**DELEGATED DECISION FOR APPLICATION FOR CERTIFICATE OF
LAWFUL DEVELOPMENT**

Reference no.: 2018/CL/94171/E

Site: 60, Station Lane, Birkenshaw, BD11 2JE

Description: Certificate of lawfulness for proposed single storey
garage extension

PROPOSED ELEVATIONS

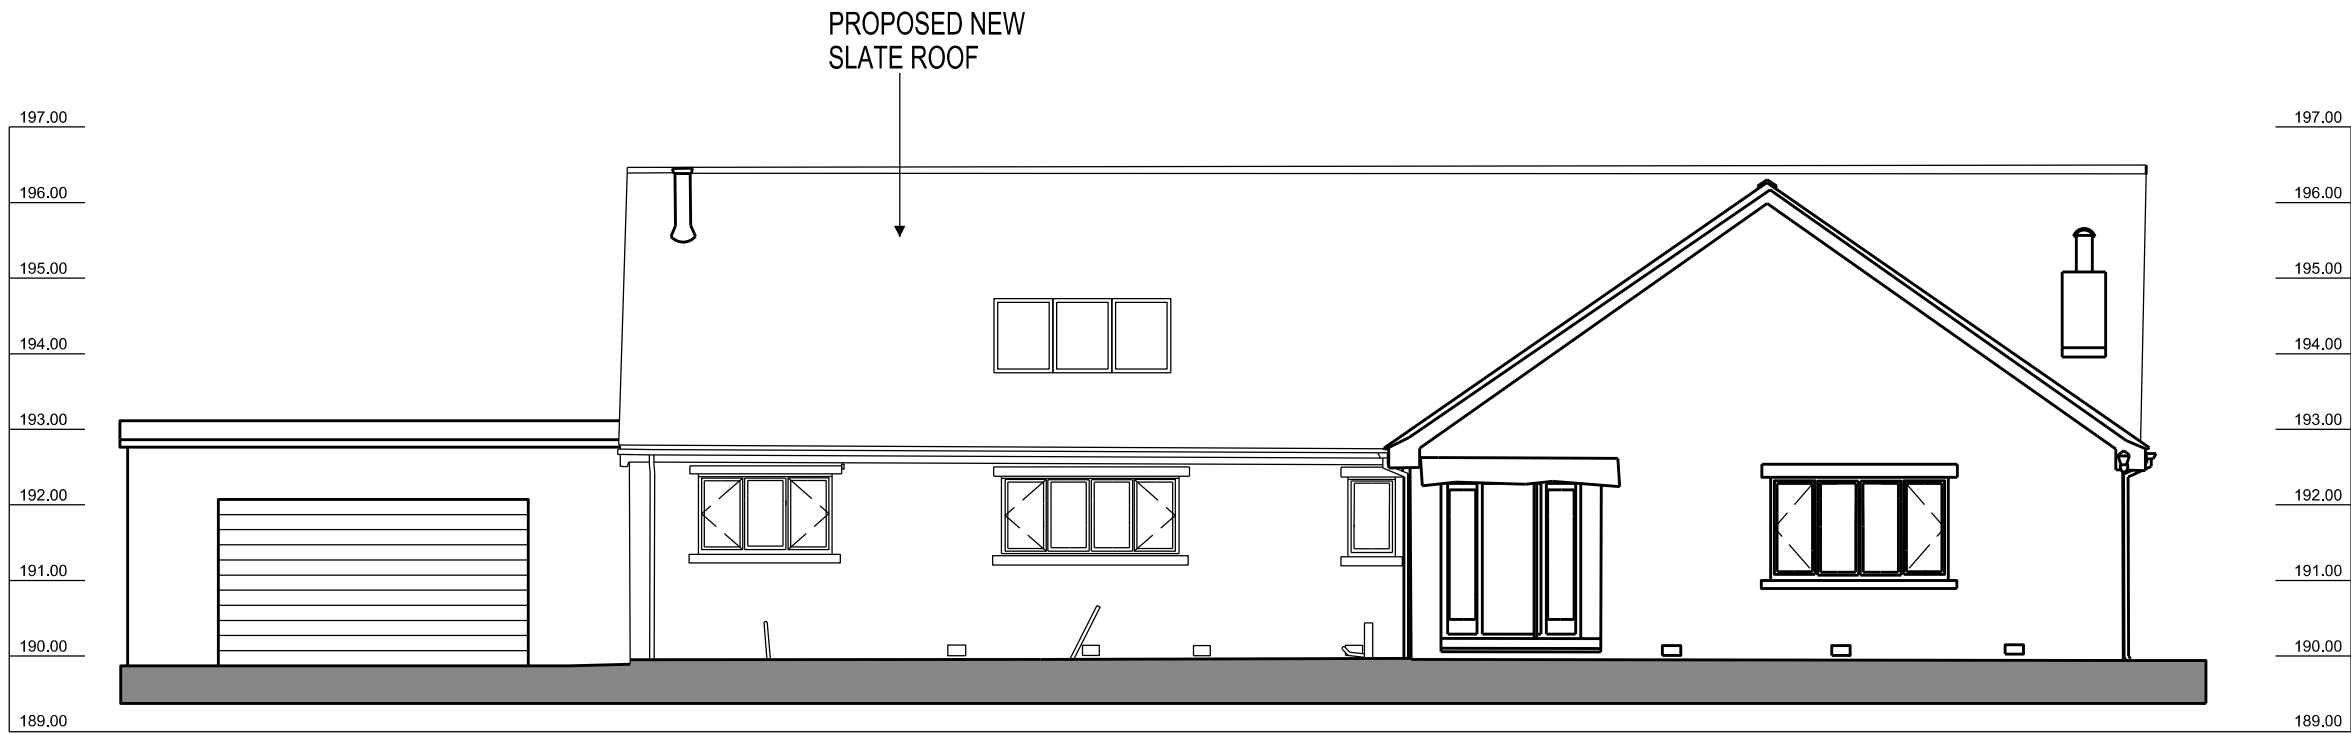
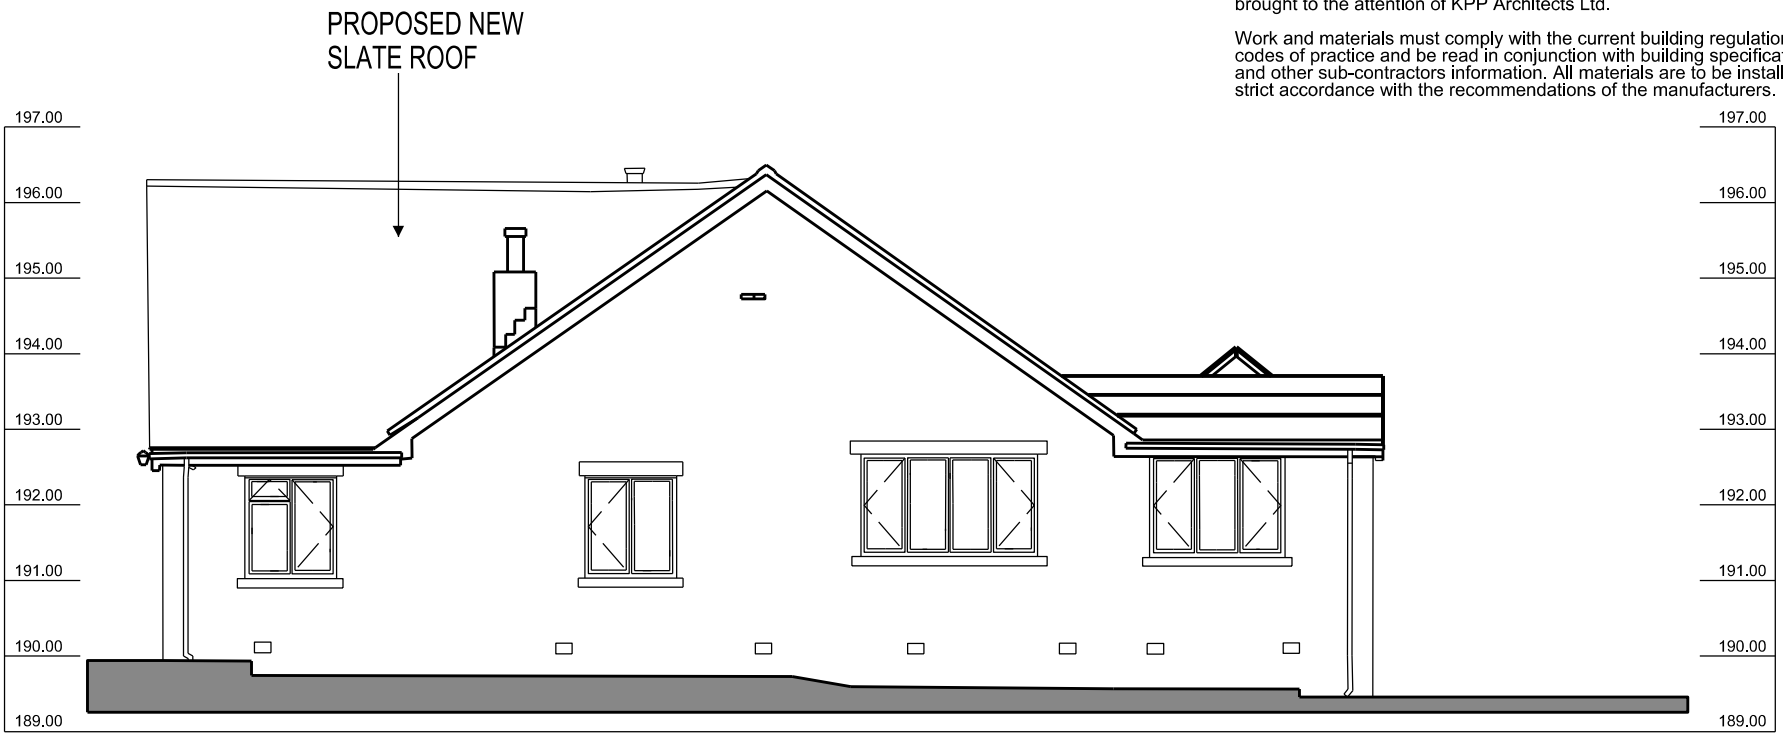
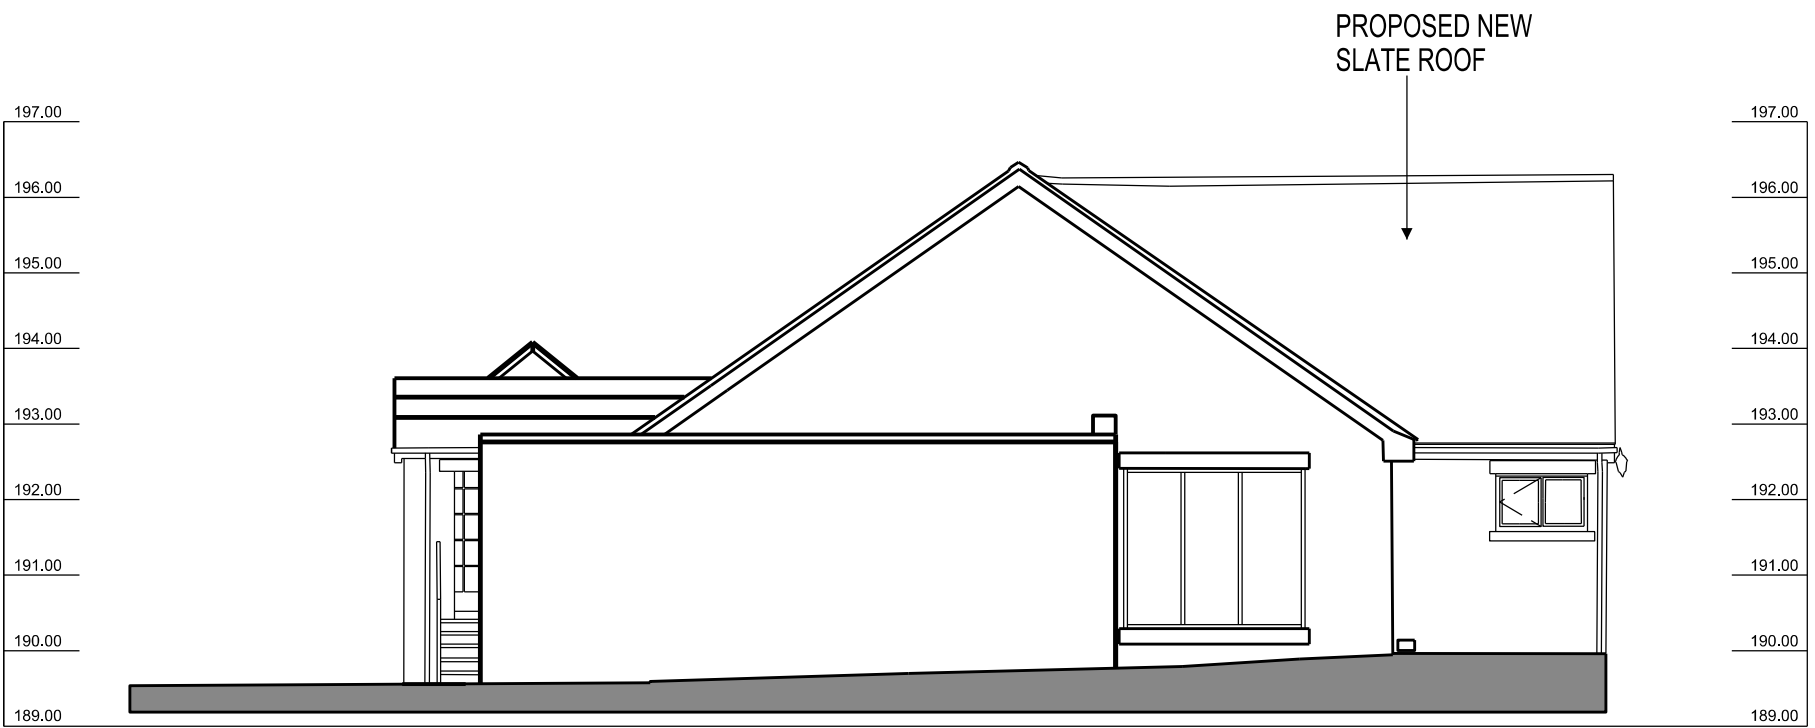
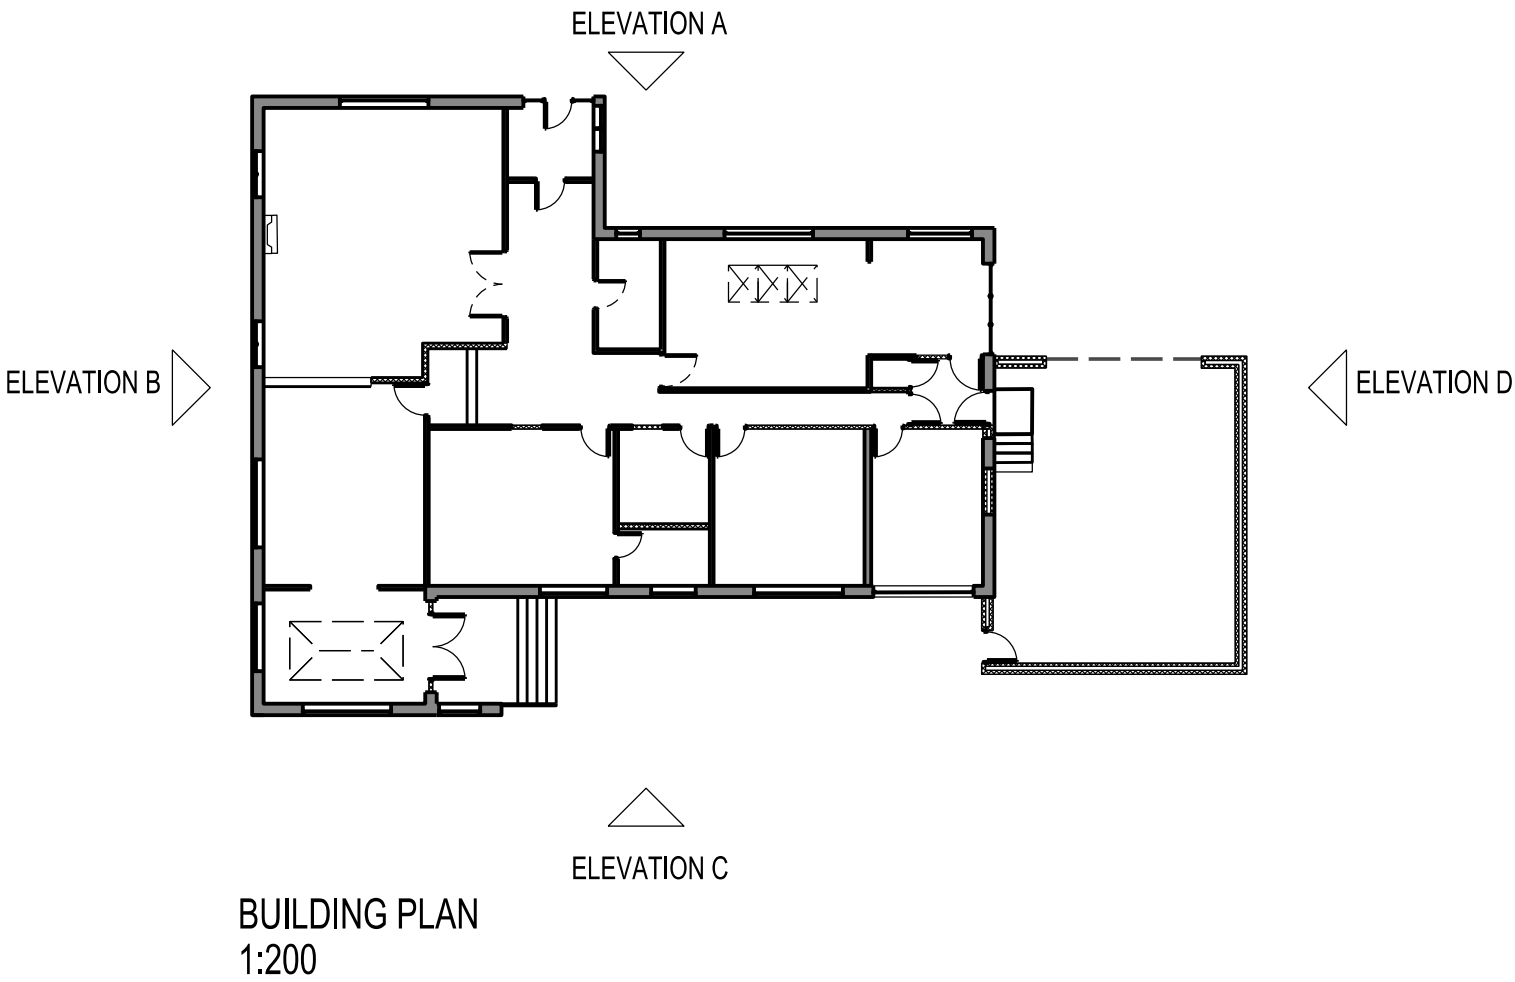
The extension would be set back 3.2m from the front elevation of the dwelling, project 6.4m from the original side wall of the property and extend out 2m beyond the rear elevation of the property.

No information has be supplied regarding the materials for construction although the extension would have a flat roof form and the plans are annotate to the effect that the existing roof would be covered with new slates.

Comment The height of the extension would not exceed the height of the highest part of the roof of the existing dwellinghouse
- (d) The height of the eaves of the part of the dwellinghouse enlarged, improved or altered would exceed the height of the eaves of the existing dwellinghouse

Comment The height of the eaves of the extension would not exceed the height of the eaves of the original dwelling.
- (e) The enlarged part of the dwellinghouse would extend beyond a wall which— (i) forms the principal elevation of the original dwellinghouse; or (ii) fronts a highway and forms a side elevation of the original dwellinghouse;

- Comment* *the extension would be within 2 m of the boundary of the curtilage of the dwellinghouse, particularly on the boundary with the adjoining property. However, the roof form would be flat therefore the overall height of the extension is 2.5m.*

- (ii) Have more than a single storey, or
 - (iii) Have a width greater than half the width of the original dwellinghouse;
- Comment* *the extension does extend out 6.4m beyond the side elevation of the dwelling. However, the property has a width of 19m. The proposed extension would therefore not exceed the limitations of (j)*

PROPOSED SITE PLAN

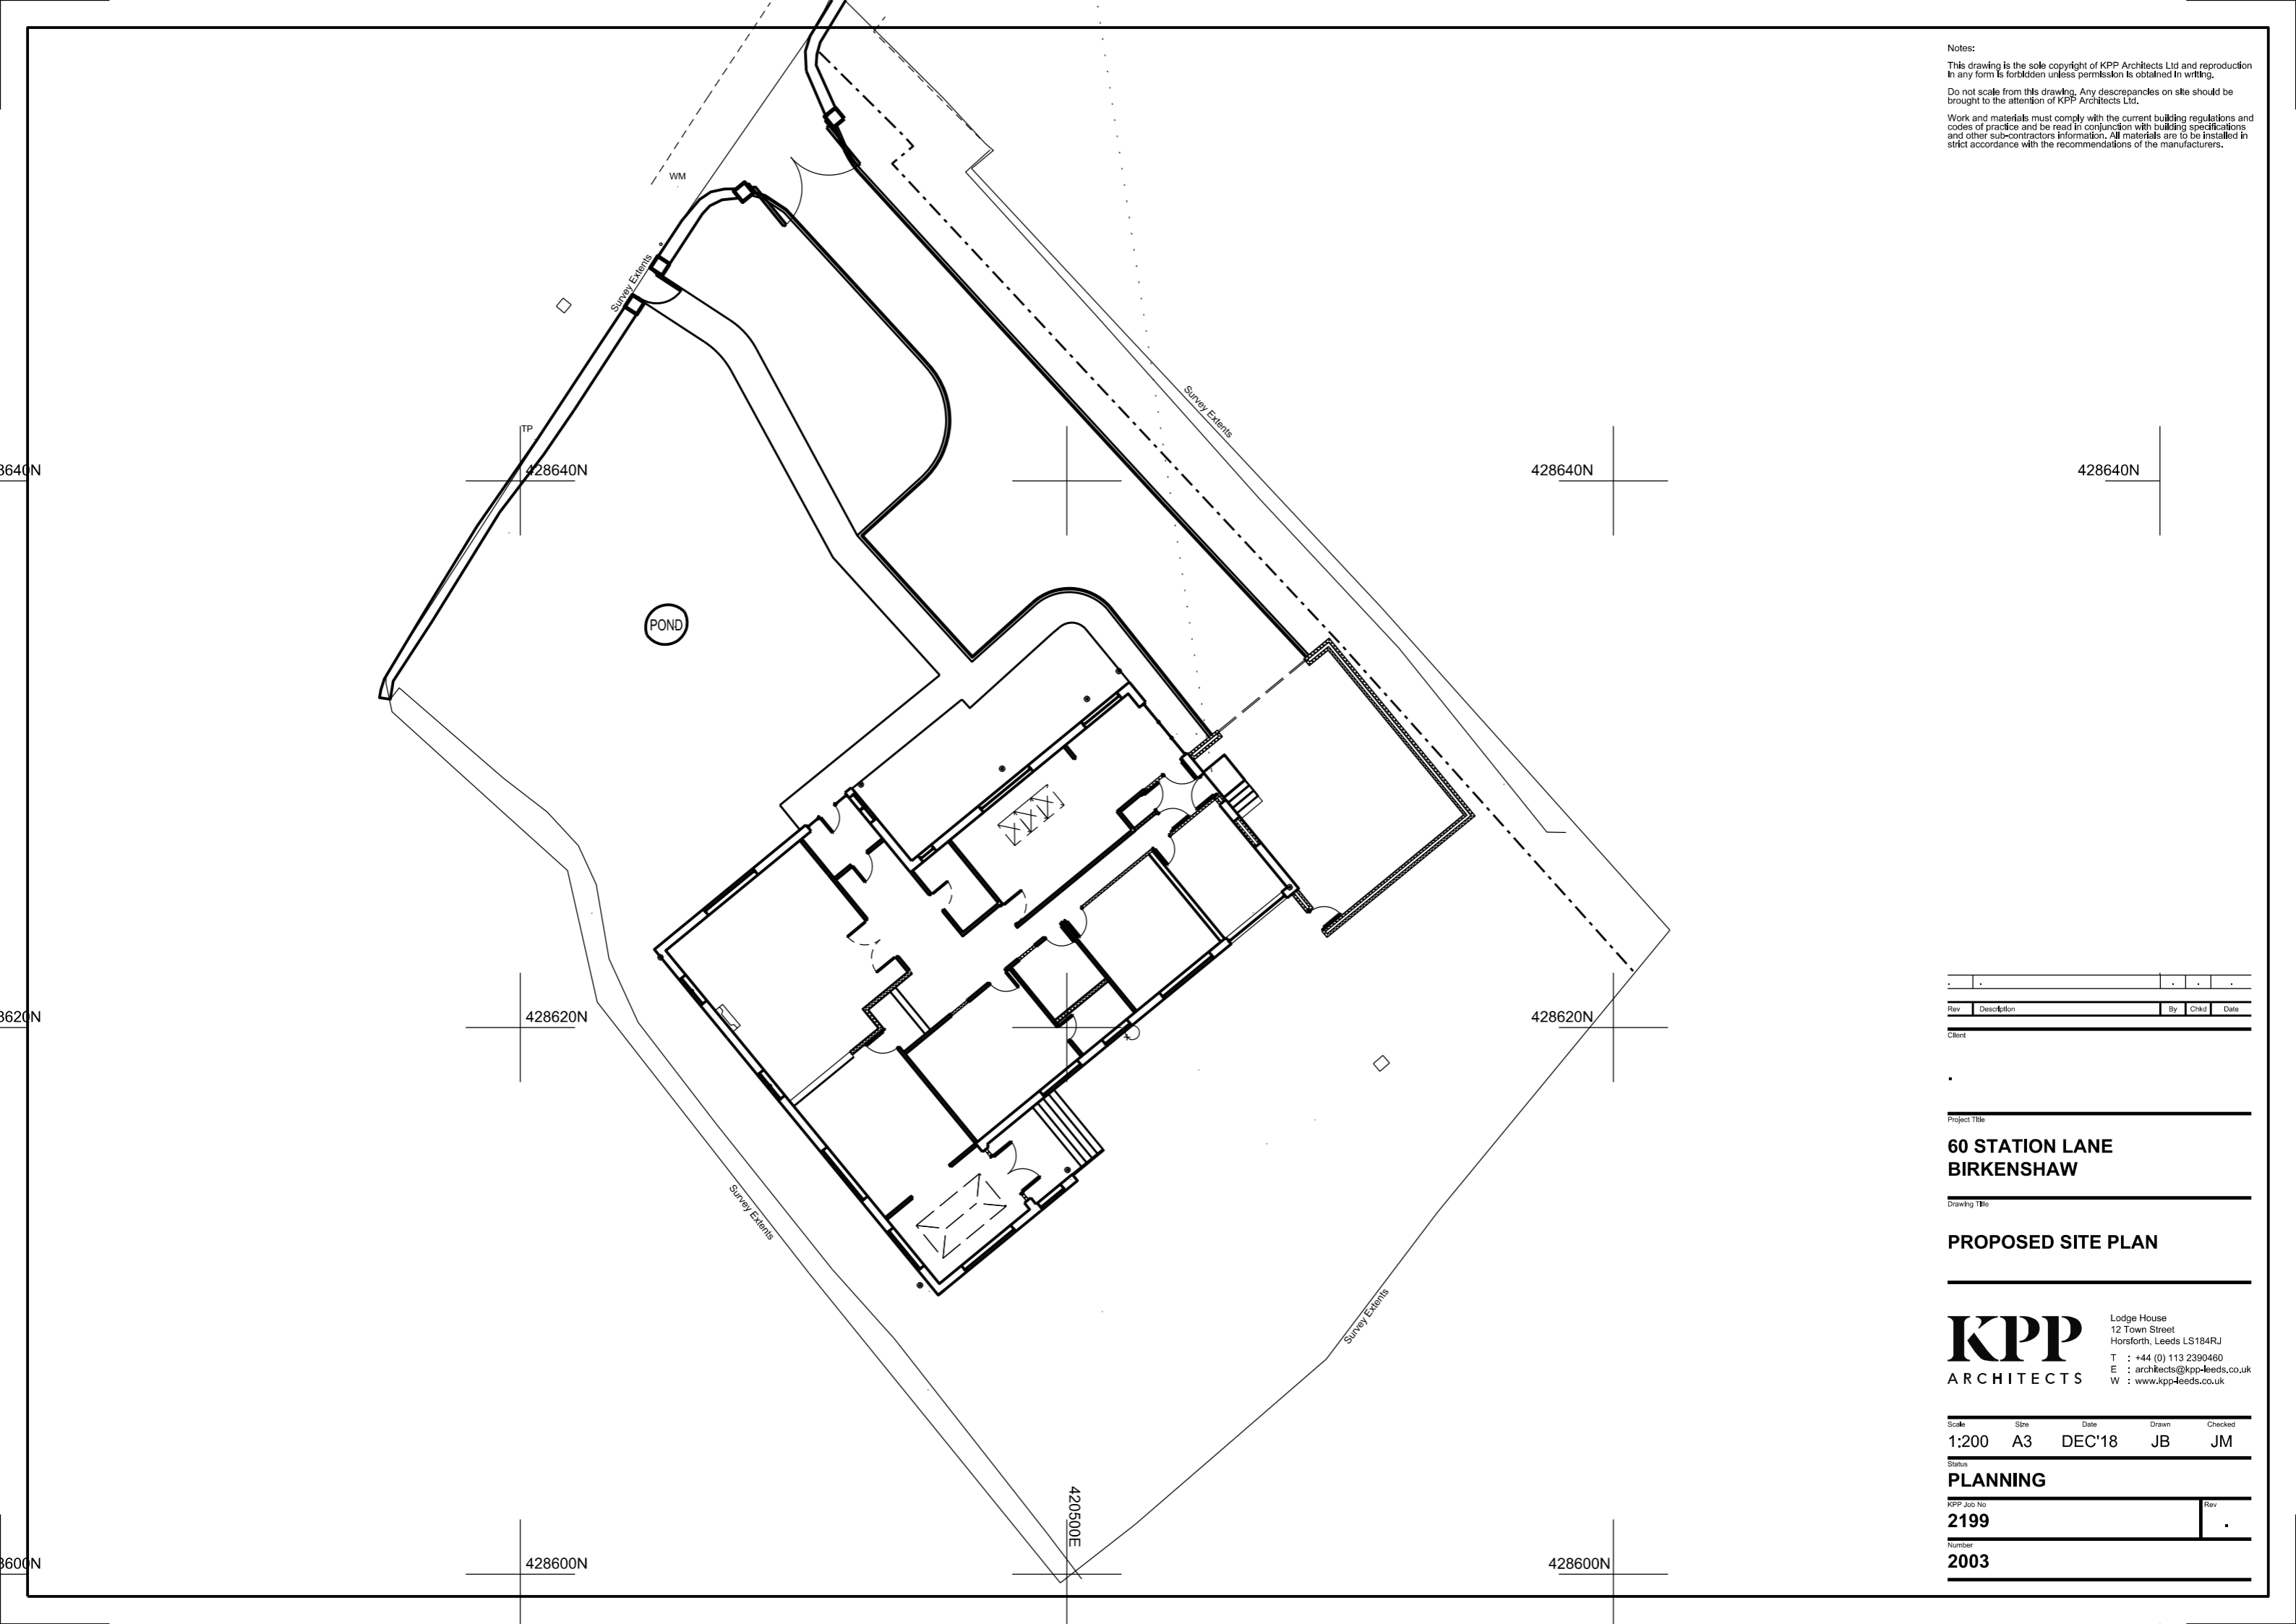
- (a) permission to use the dwellinghouse as a dwellinghouse has been granted only by virtue of Class M, N, P or Q of Part 3 of this Schedule (changes of use);
Comment *Permission for this dwelling was not granted by virtue of Class M, N, P or Q of Part 3 of this Schedule (changes of use).*
- (b) as a result of the works, the total area of ground covered by buildings within the curtilage of the dwellinghouse (other than the original dwellinghouse) would exceed 50% of the total area of the curtilage (excluding the ground area of the original dwellinghouse);
Comment *As can be seen from the location plan provided by the applicant, the proposed extension would not take up more than 50% of the*

Comment The extension would not protrude beyond the principal elevation of the original dwellinghouse nor would it directly front a highway.
- (f) Subject to paragraph (g), the enlarged part of the dwellinghouse would have a single storey and— (i) Extend beyond the rear wall of the original dwellinghouse by more than 4 metres in the case of a detached dwellinghouse, or (ii) 3 metres in the case of any other dwellinghouse, (iii) Exceed 4 metres in height;

Comment The extension has a projection to the rear of the dwelling, which is an detached property and the proposed projection is 2m from the original rear wall of the dwelling.
